**BCA Compliance Report
Development Application Submission**

**Blacktown Mt Druitt Hospital
Stage 1 Expansion &
Sub Acute Projects
Main Building**

Health Infrastructure

29 June 2012

LEVEL 4

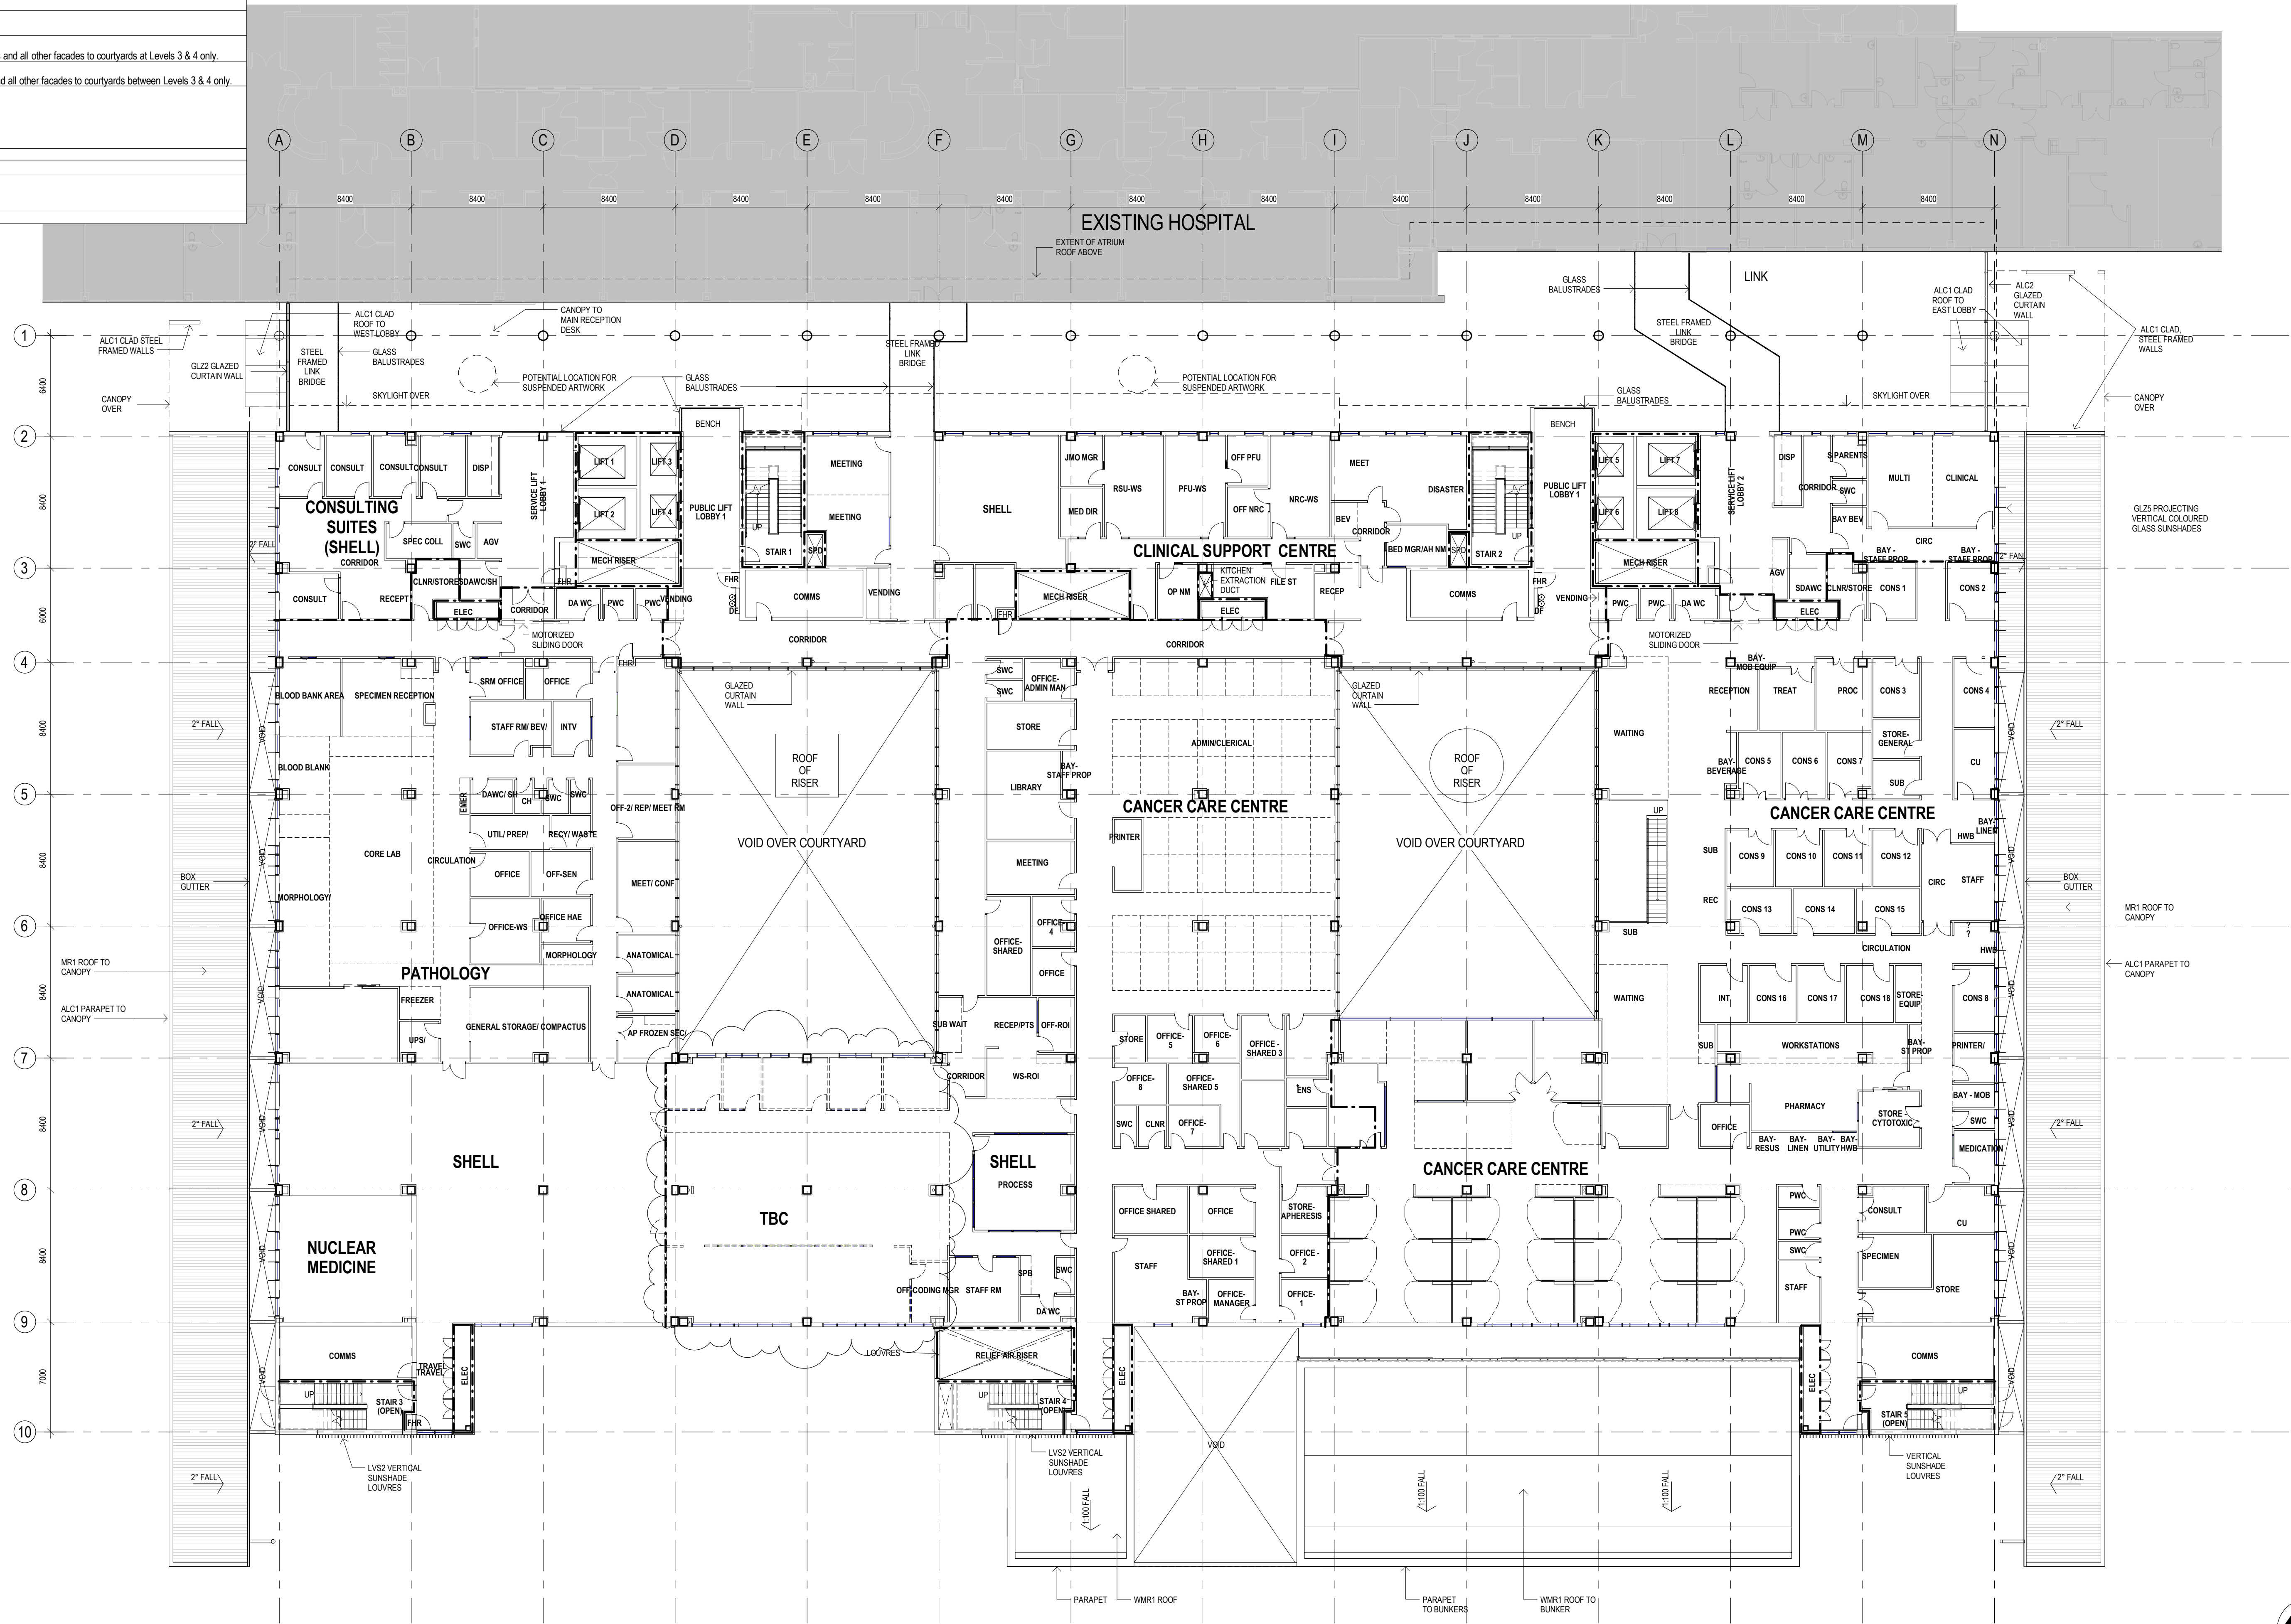
- The floors to the link bridges on Level 4 are proposed to be non fire rated; and
 - The proposed roof to the atrium is proposed not to be provided with an FRL.

The 'Hospital Street' Atrium connects multiple fire compartments of the existing building by virtue of the fact that the existing bounding construction of the existing hospital would not comply with Clause C2.7. In this instance, the fire compartment sizes exceeds 2,000m² for a patient care area in accordance with Clause C2.5 and 5,000m² for the maximum fire compartment size for a Class 9a building in accordance with Table C2.2. This is applicable on Levels 3 & 4.

In this instance we understand that the client proposes to address the non compliance via a Fire Engineering Assessment to be undertaken by a qualified Fire Safety Engineer in order to demonstrate compliance with the relevant Performance Requirements of the BCA.
